CITY OF ALBUQUERQUE

**Re: Champion Express Car Wash
211 Unser Blvd SW
Request for Certificate of Occupancy- 30 Day Temp
Transportation Development Final Inspection
Plan Approval Date 2-23-23 (K10D064)
Certification dated 5-8-24**

Based upon the information provided in your submittal received 5-8-24, Transportation Development has no objection to a 30-Day Temporary Certificate of Occupancy. This letter serves as a "green tag" from Transportation Development for a 30-Day Temporary Certificate of Occupancy to be issued by the Building and Safety Division.

**TRAFFIC CIRCULATION
LAYOUT APPROVED**
Ernest Armijo 3/9/2023
Signed Date

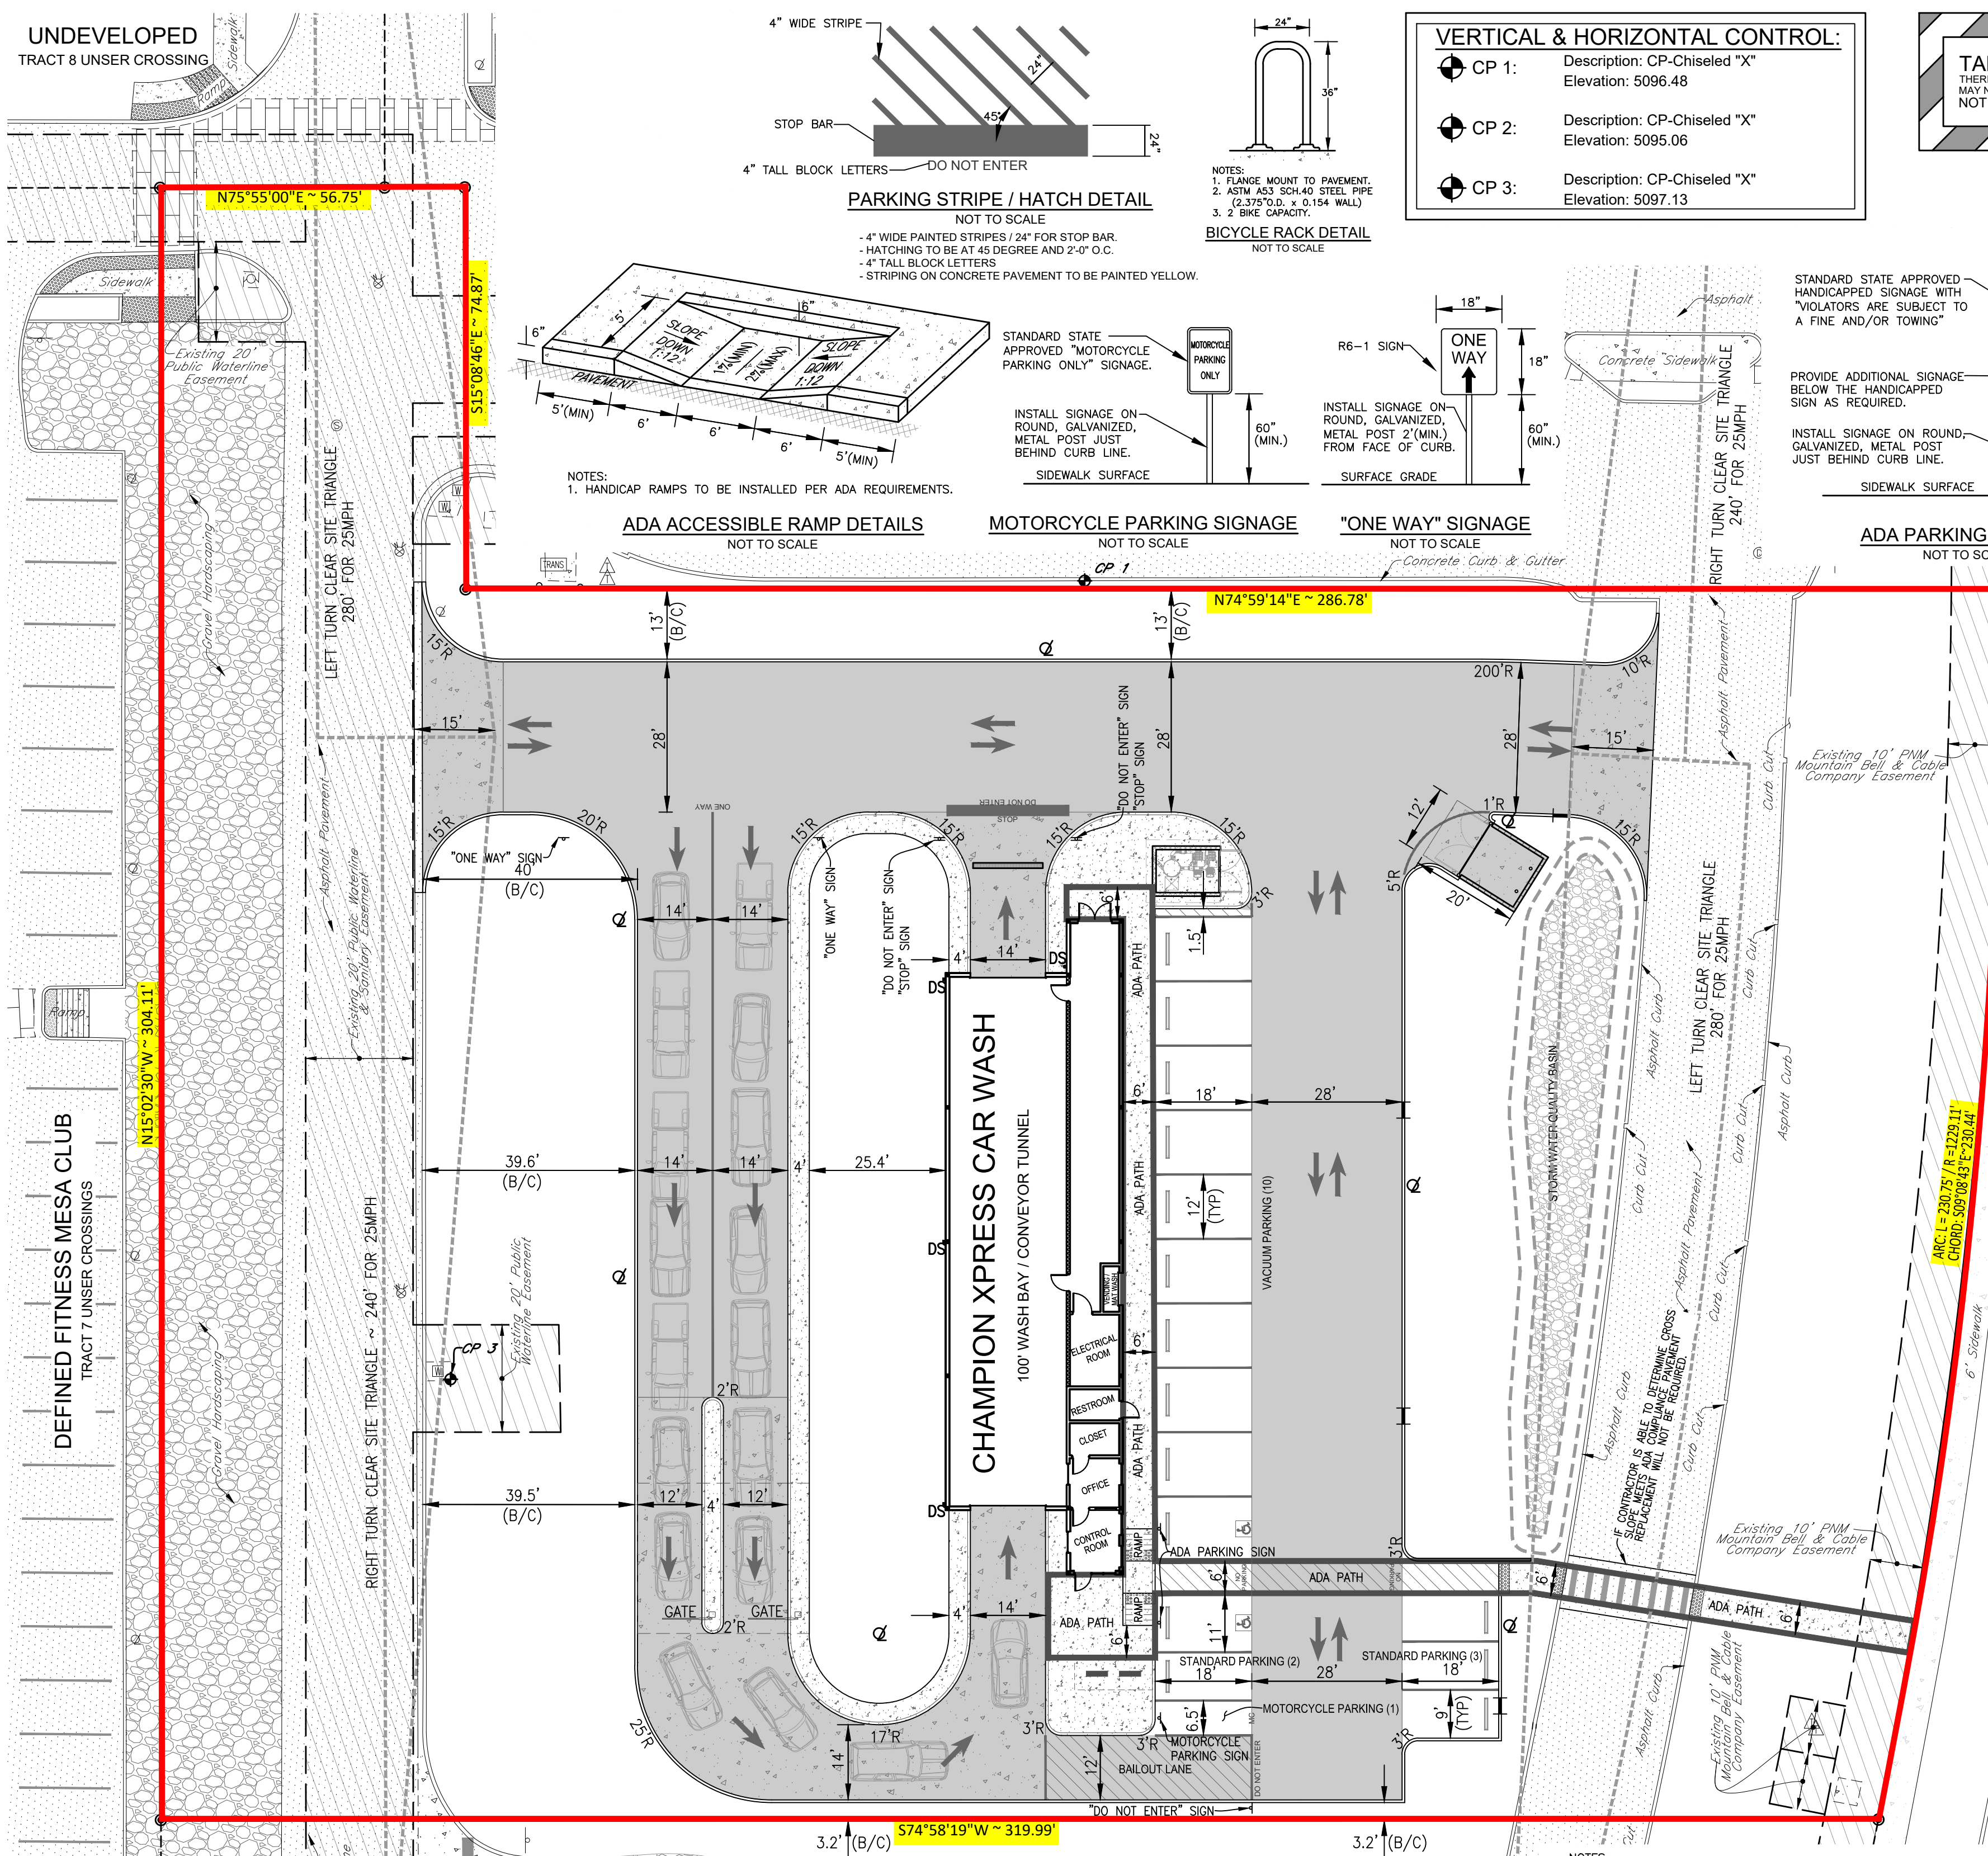
1. There was equipment, in addition to the gate foundation, installed in the sidewalk adjacent to the entry drive that makes the sidewalk impassable. If this is acceptable, please revise the as-built drawing.
